Lane Cove Council

13 May 2019

Lane Cove West Data Centre – 1 Sirius Road, Lane Cove West Notice of Exhibition (SSD 9741)

BULK EARTHWORKS QUANTITIES

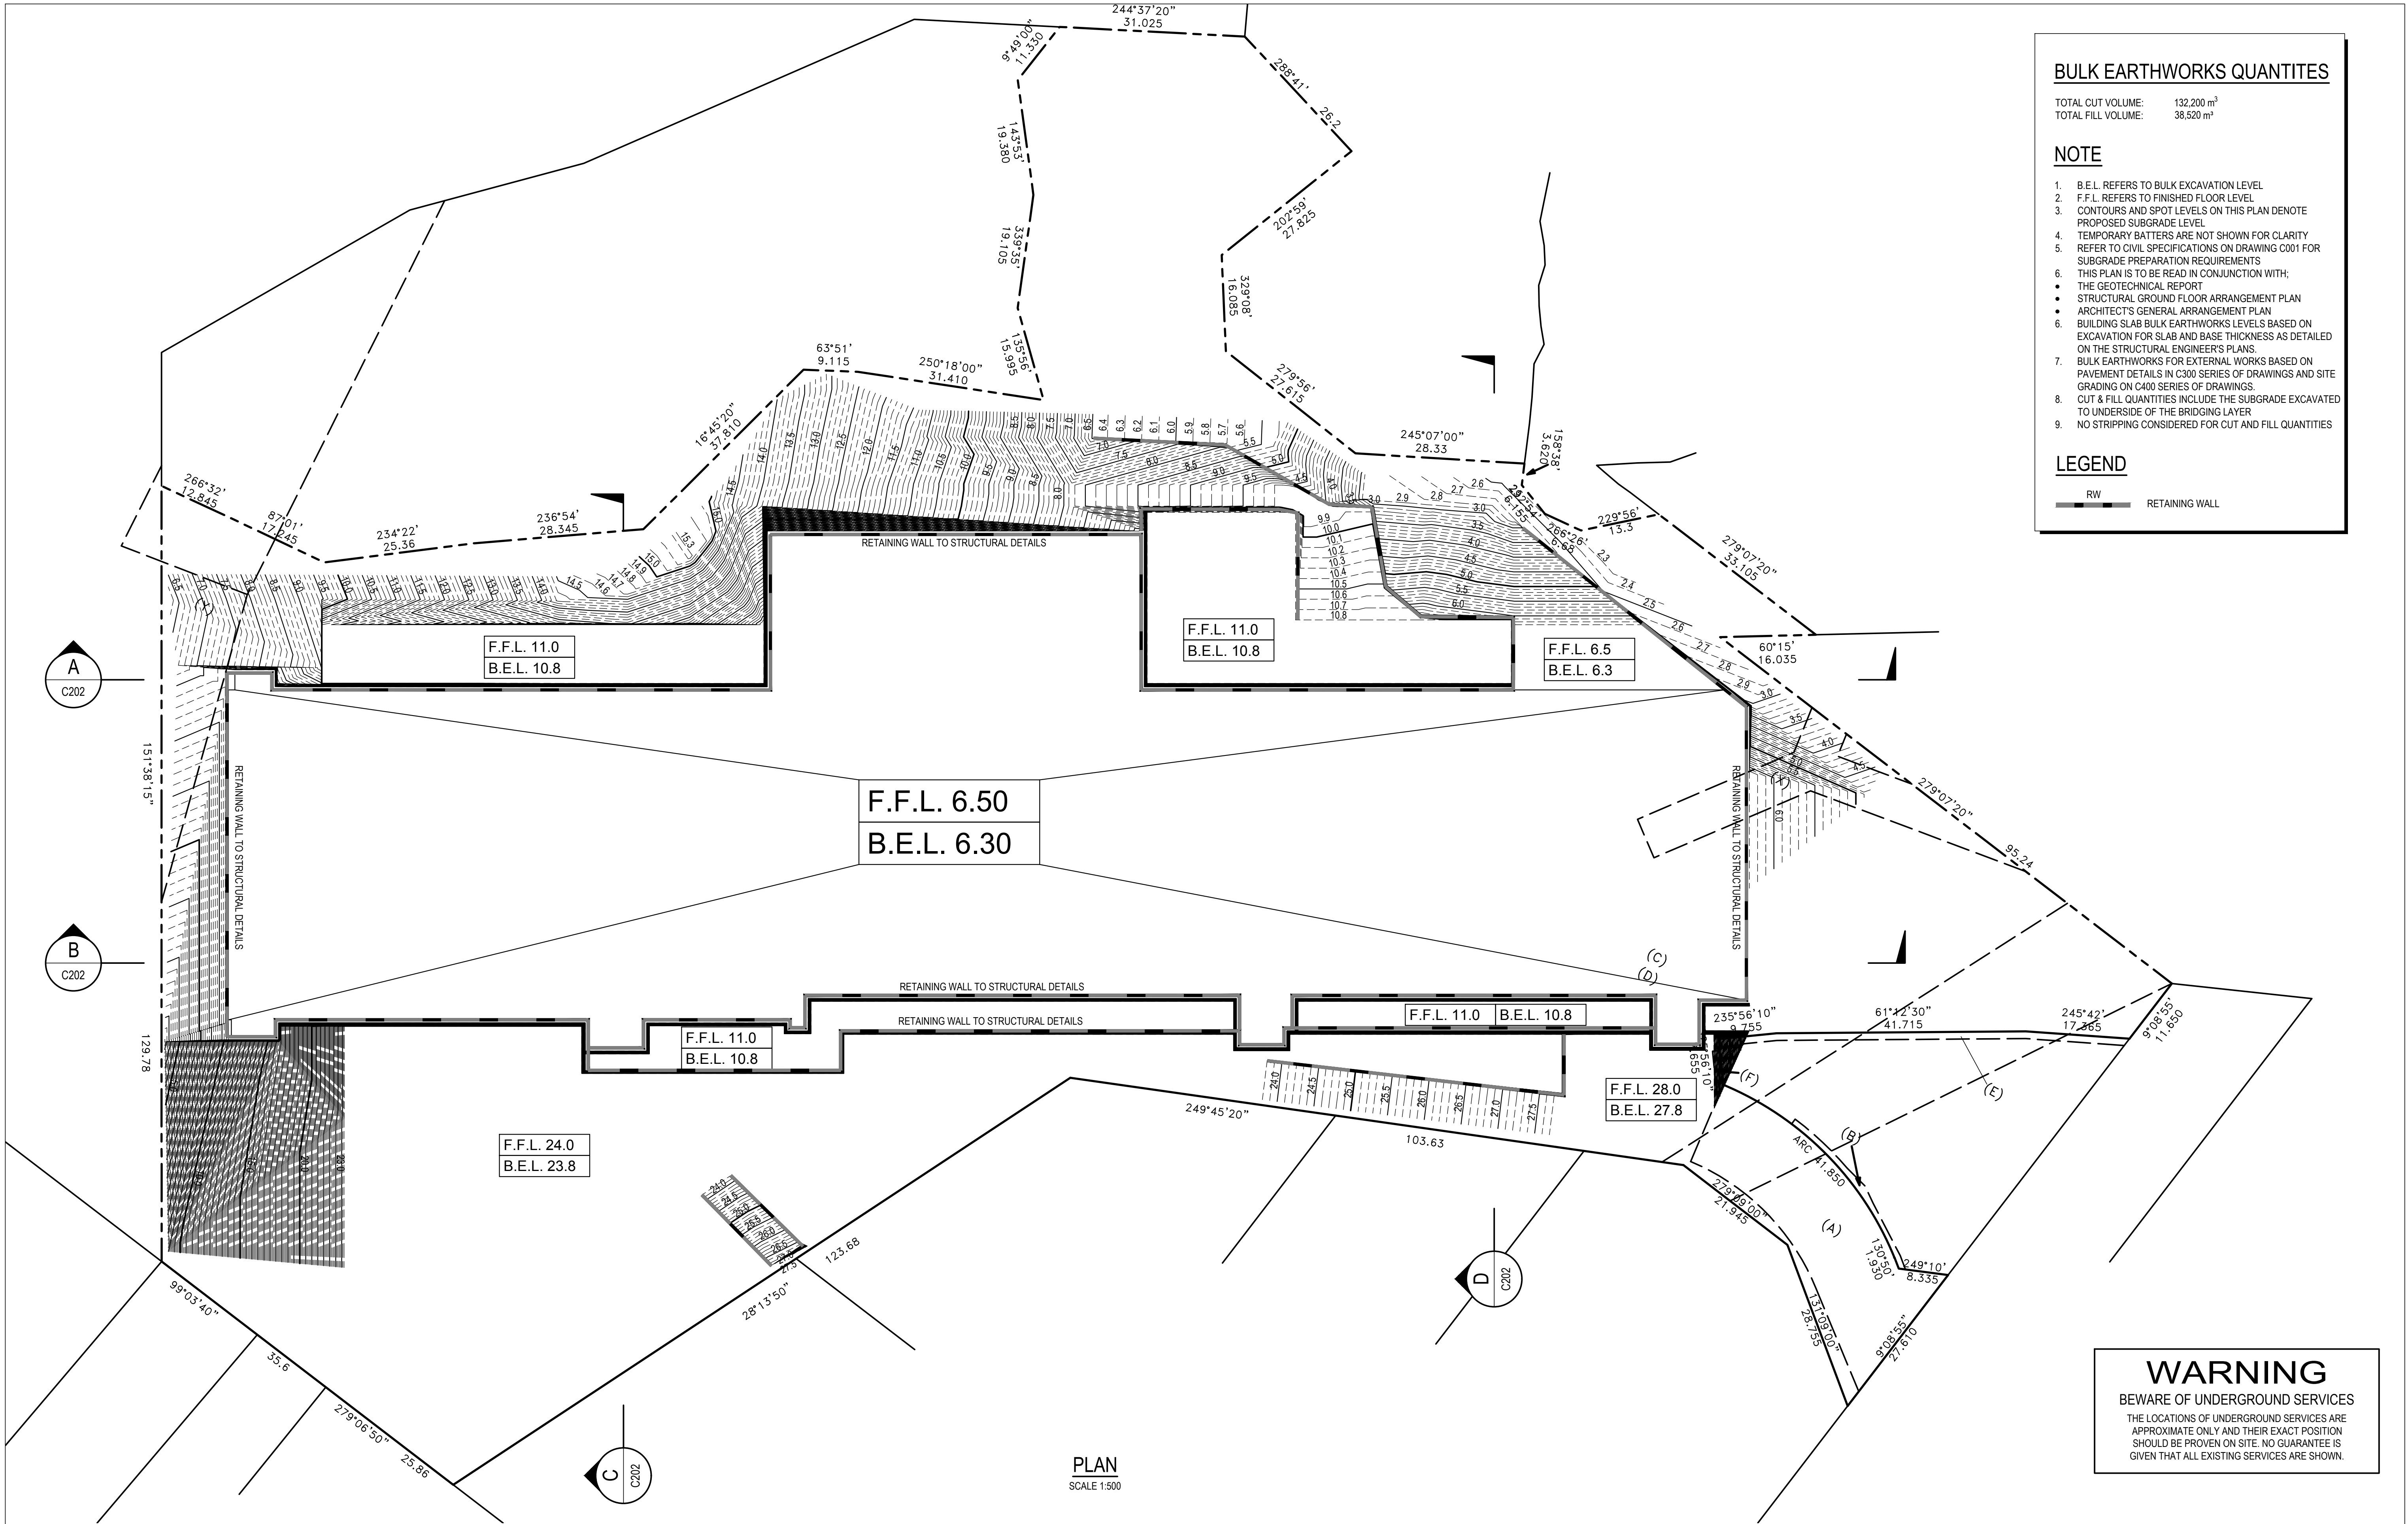
- Soft vegetated batters should be incorporated rather than hard retaining walls. In particular the retaining walls adjacent to the north road should be reconsidered to ensure the proposal better blends with the natural setting of the site;
- The rooftop condensers should be screened to soften their visual impact; and
- The 3-storey plant building north of the lower access road should be relocated to the southern end of the site where it would be less visually prominent.
- Consider adding fill externally to the building to reduce the visual impact of the building

EROSION AND SEDIMENT CONTROL

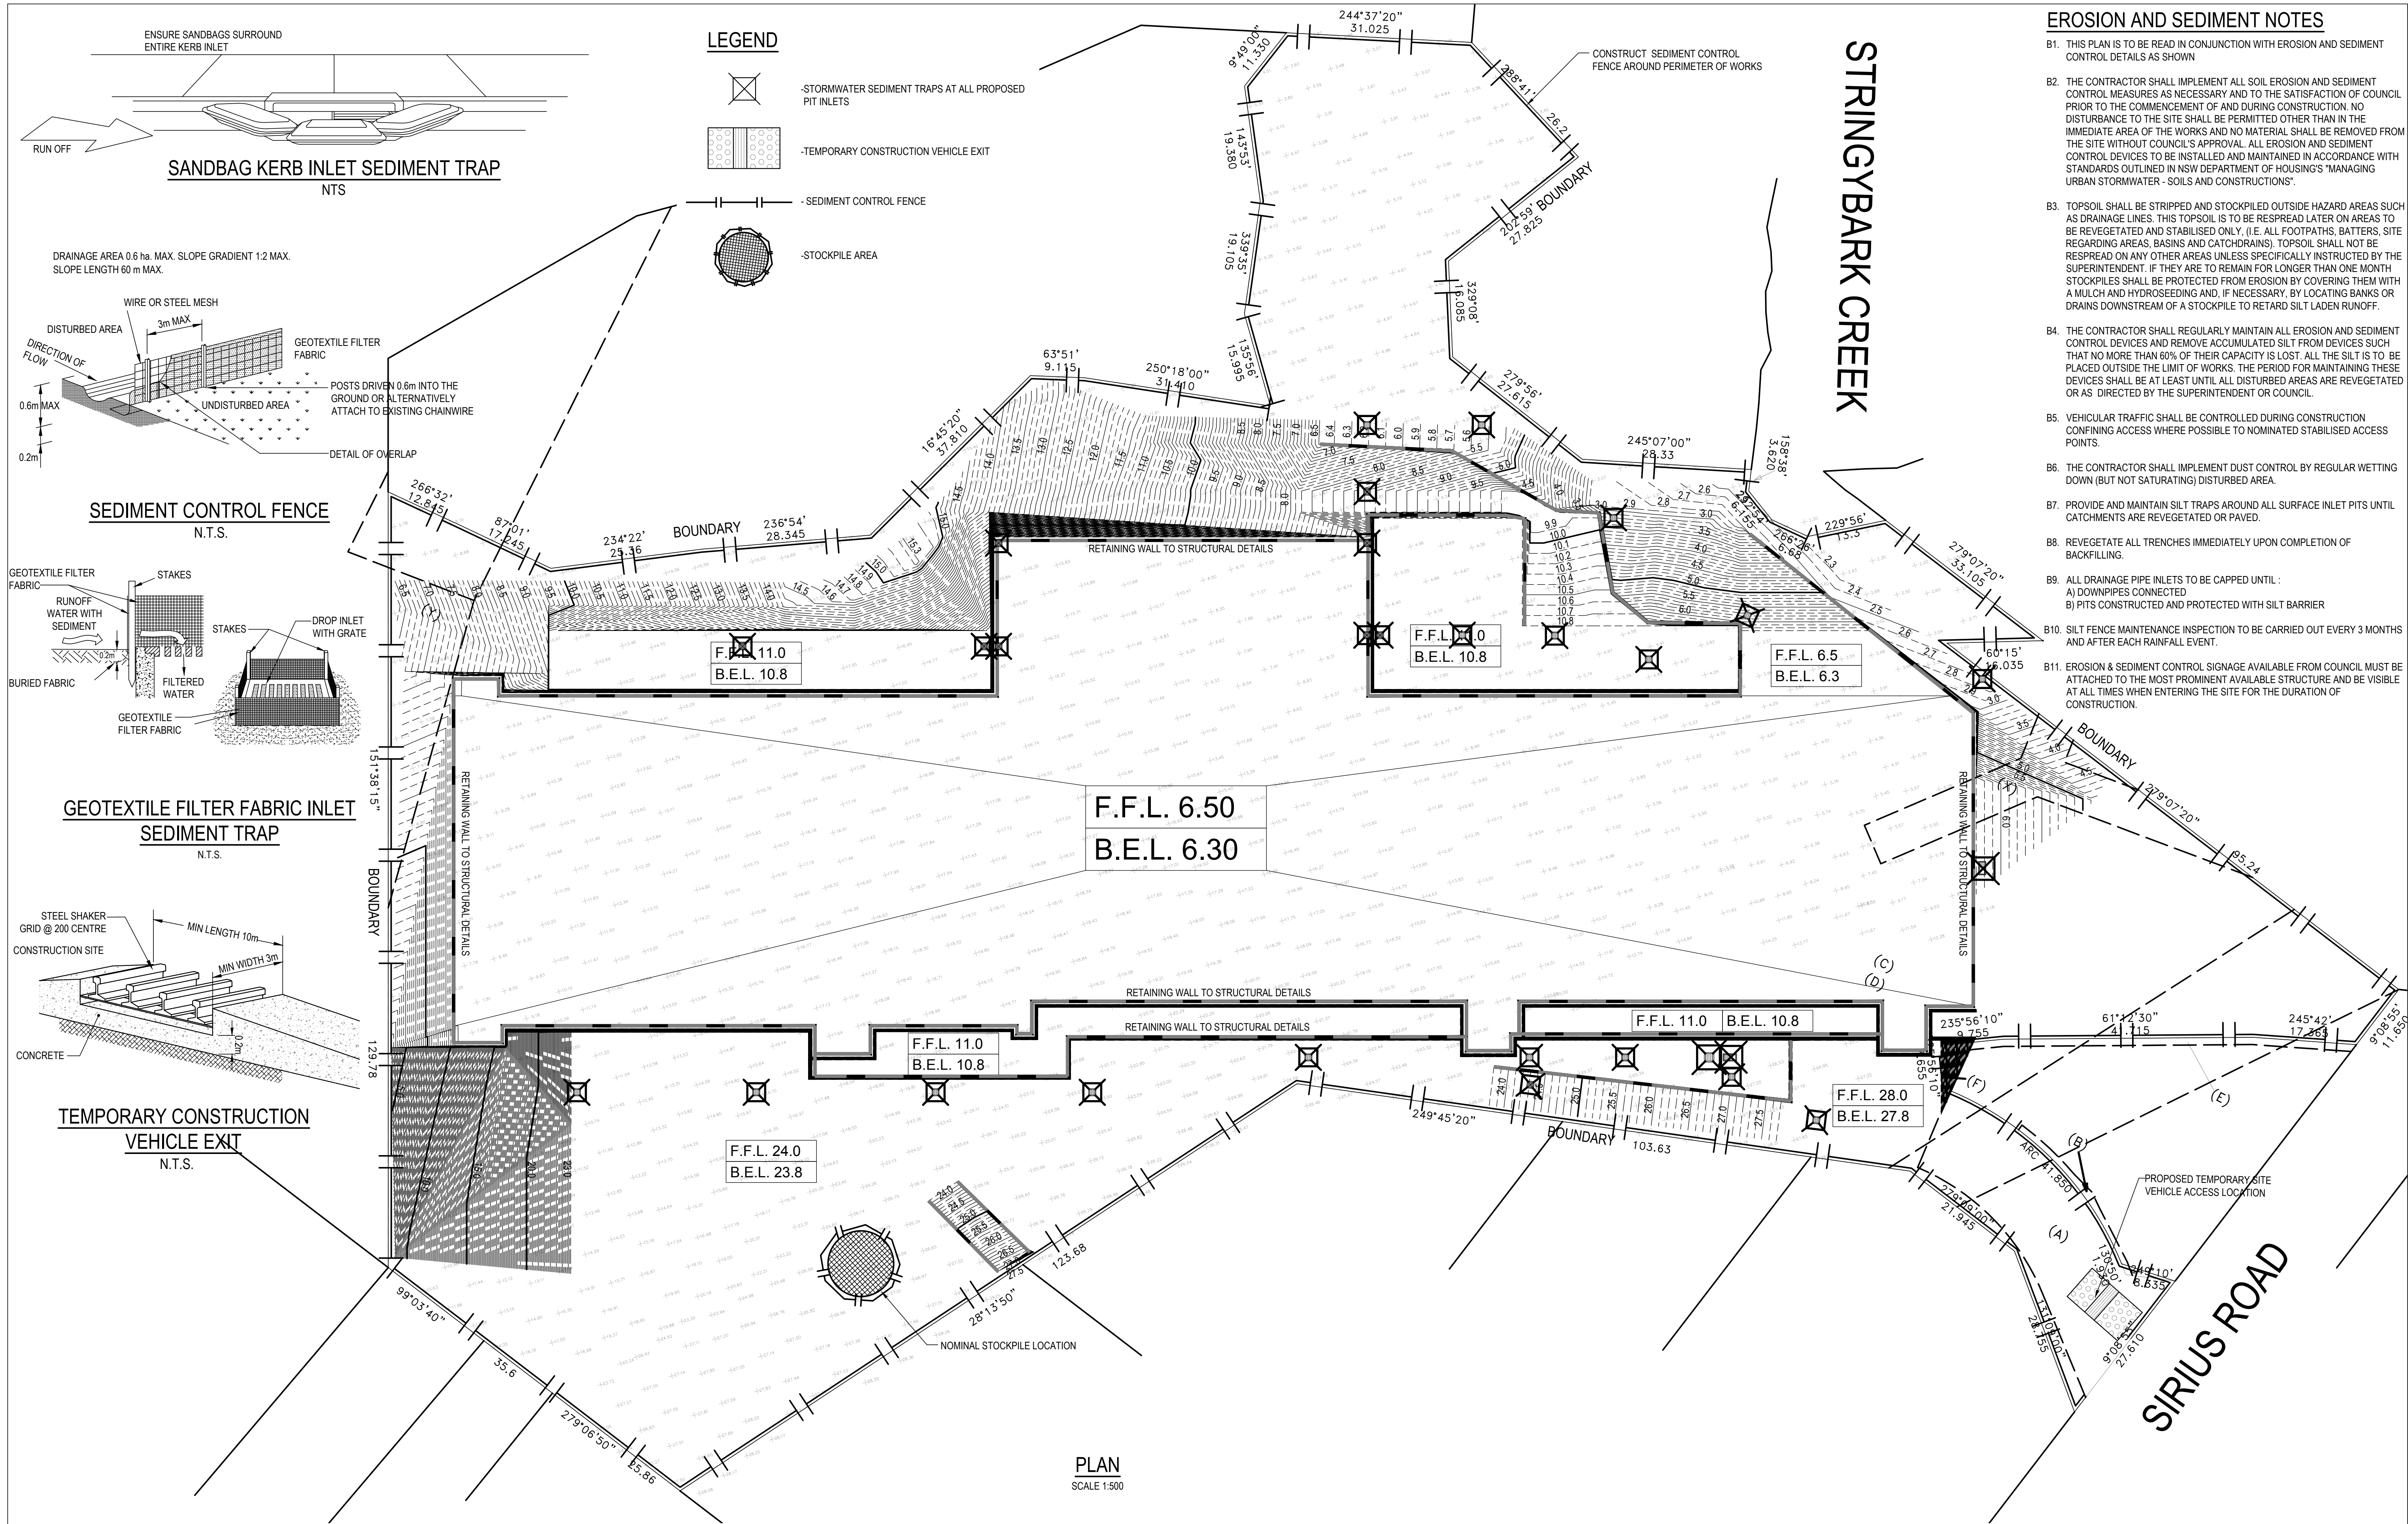
- An amended Tree Protection Plan which shows additional protection measures and the impacts on proposed trees to be retained;
- An amended Sediment Control Plan with consideration being shown to adjoining endangered wetland vegetation and other bushland vegetation;
- A Loading Management plan is required for the site; and
- A study on the overall impacts of the collecting, piping and redirecting a large percentage of the catchment area to adjoining Ecologically Endangered and Sensitive Vegetation.
